Planning application FG/172/17/HH

PROPOSED ELEVATIONS 1:100@A3

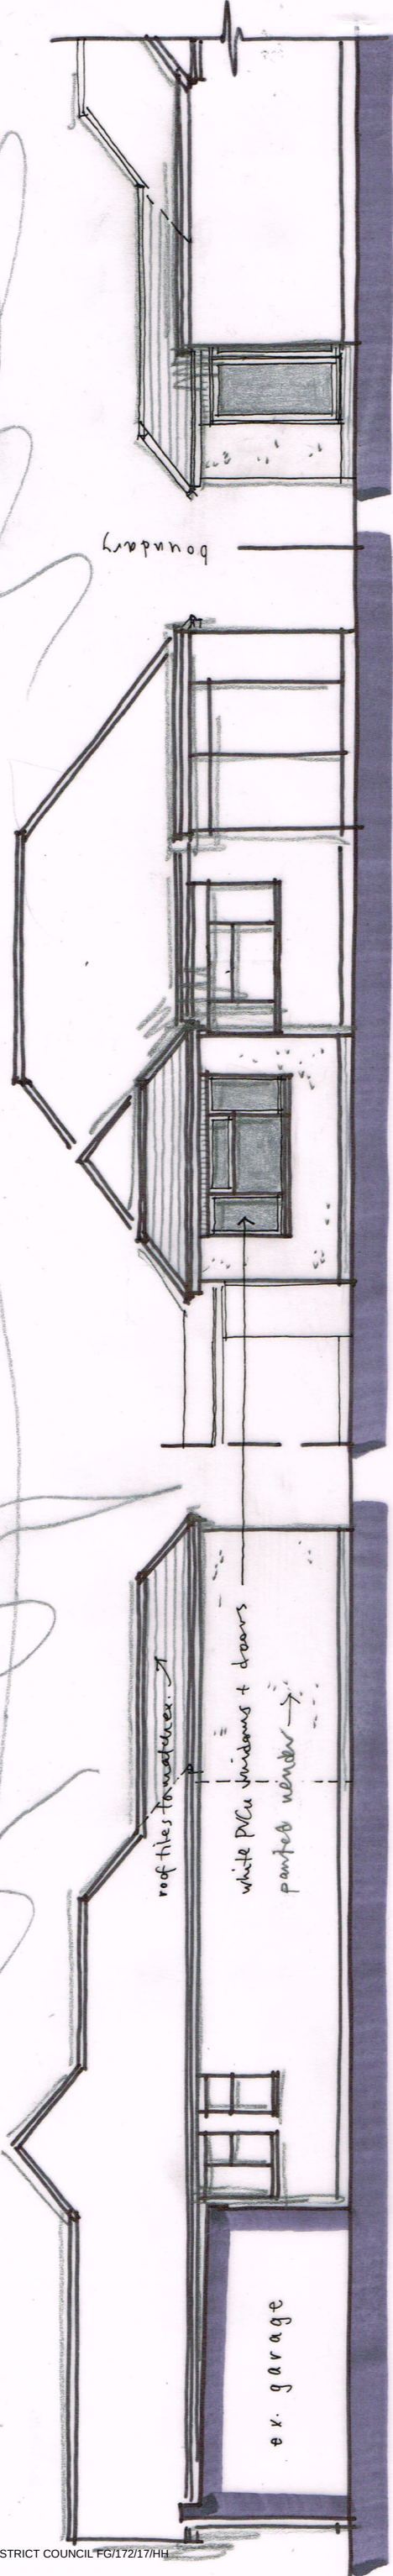
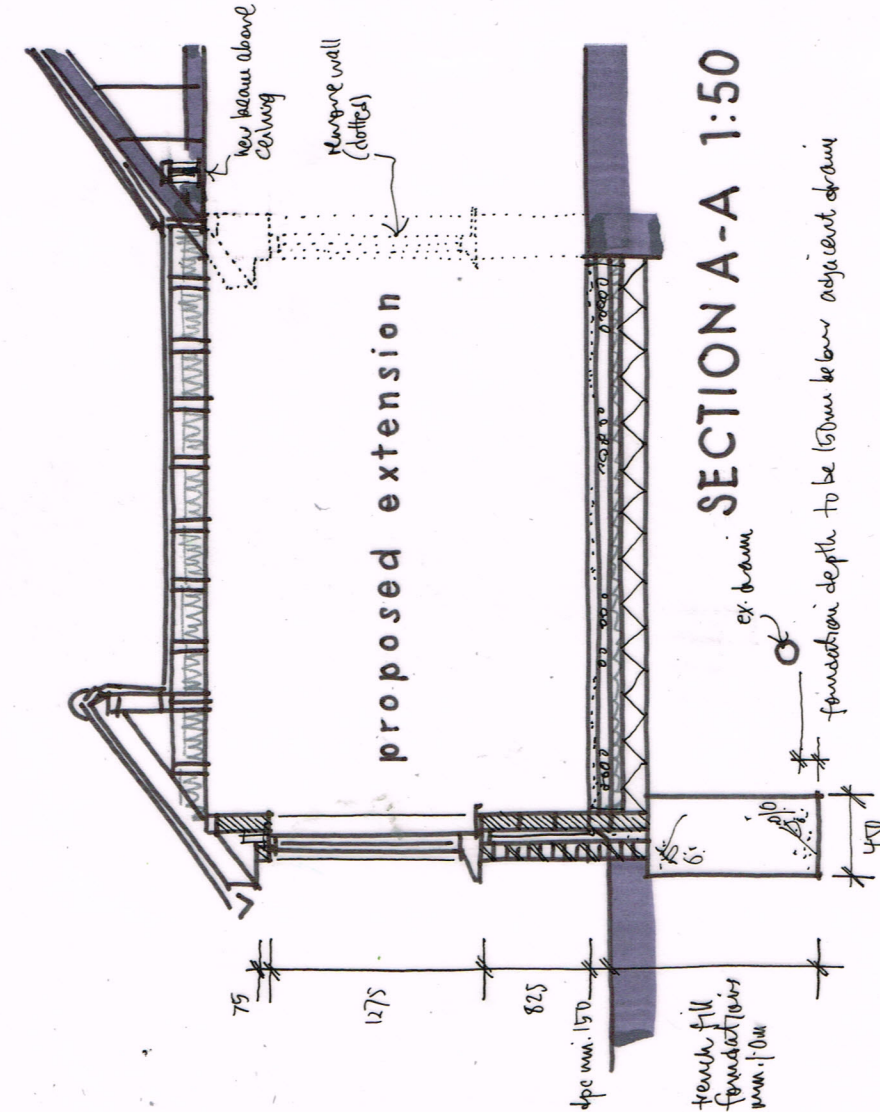
3. The rendering has already been actioned and is not in keeping with the adjacent properties.

GROUND FLOOR PLAN 1:50

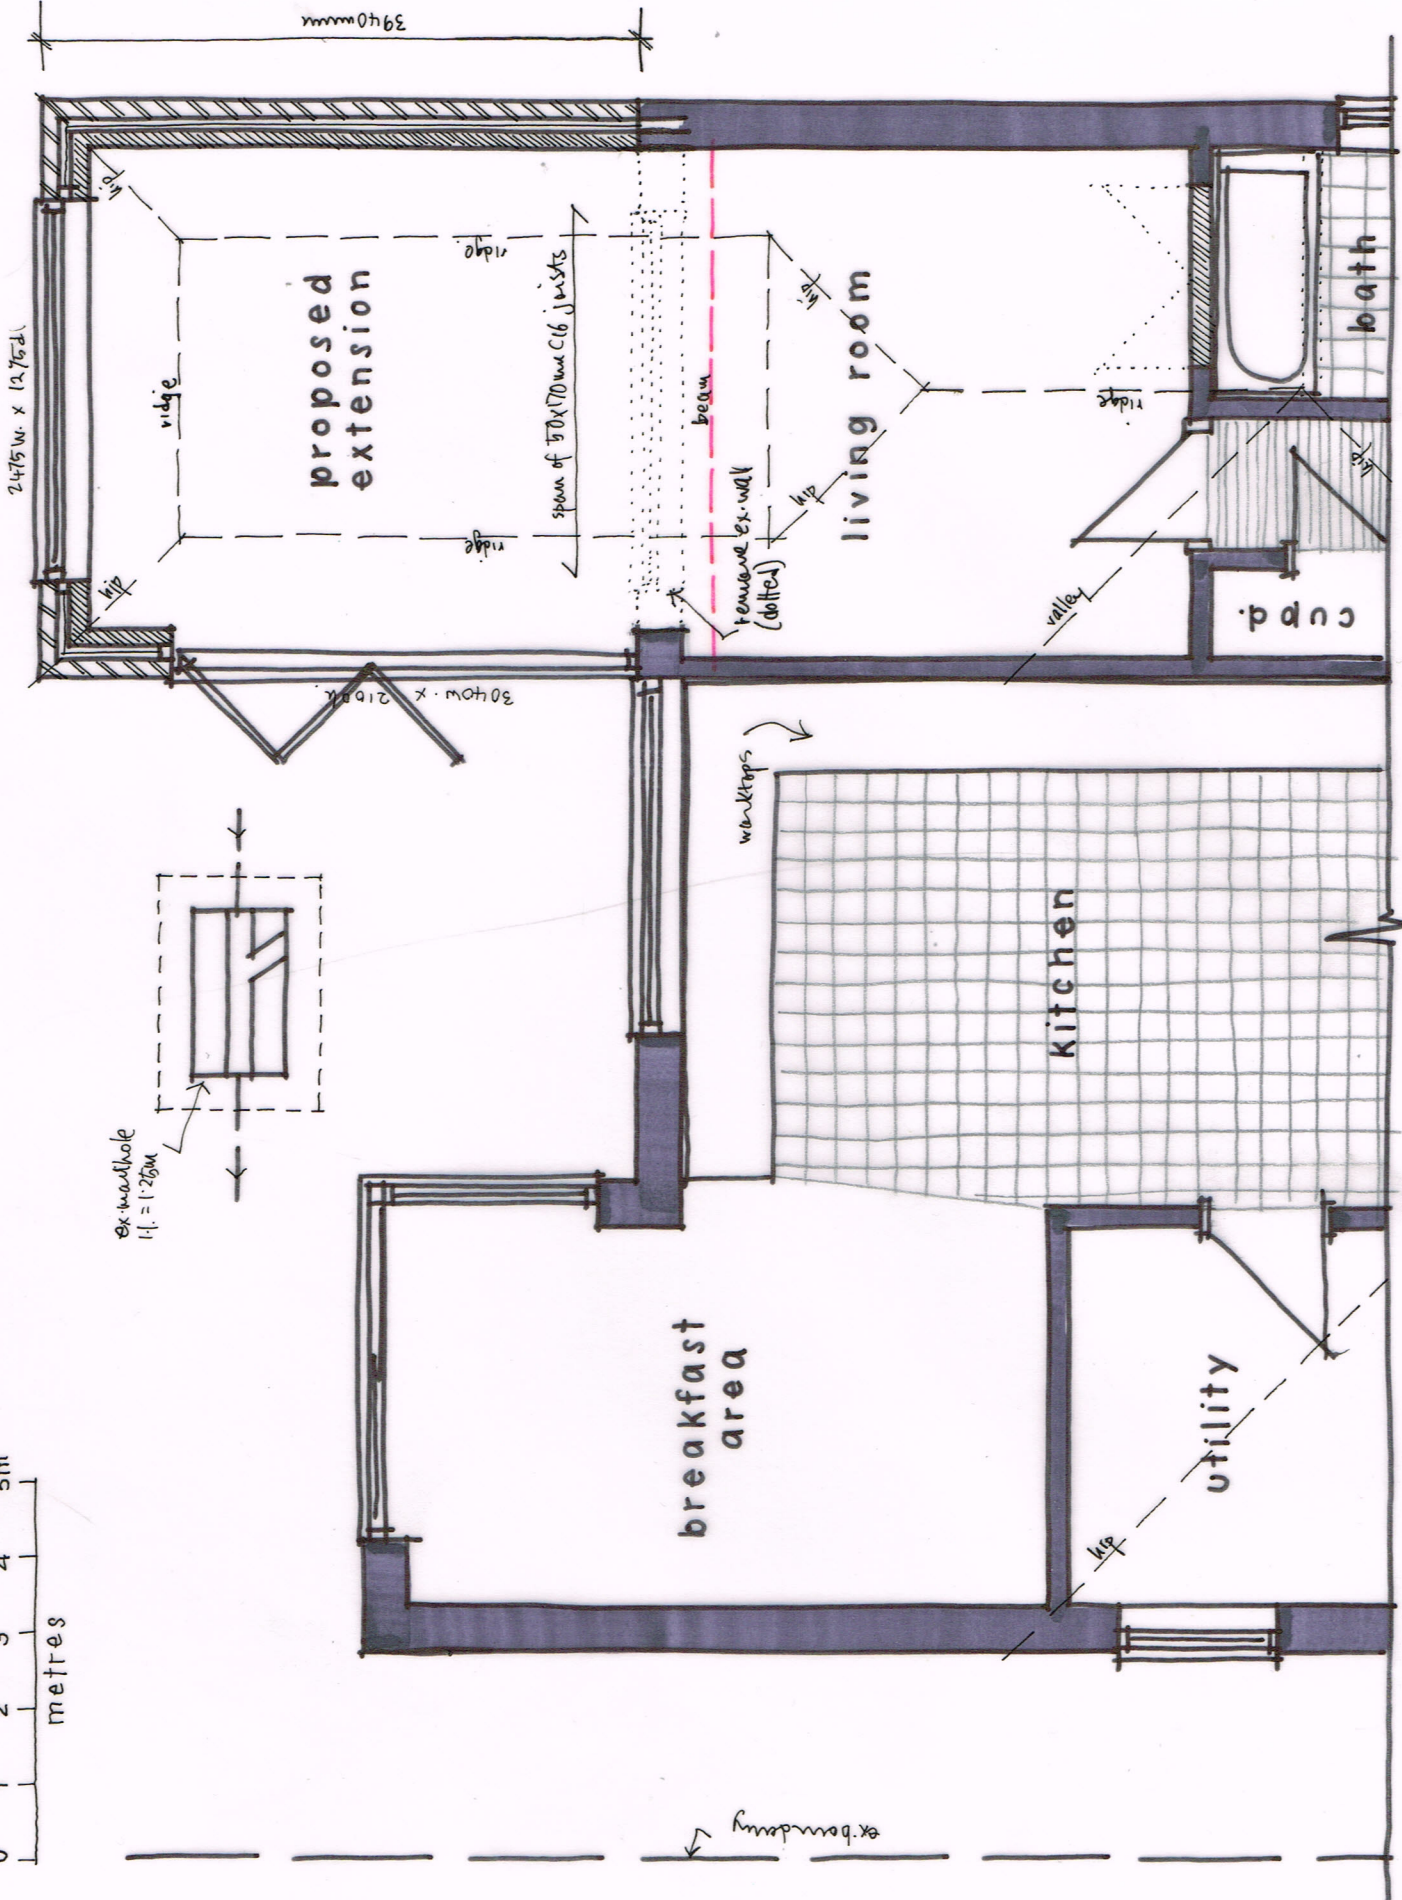
1. There are no bedrooms on the plans

I am led to believe there are to be four.

2. The plans seem to indicate that the drains are to be covered and not moved.
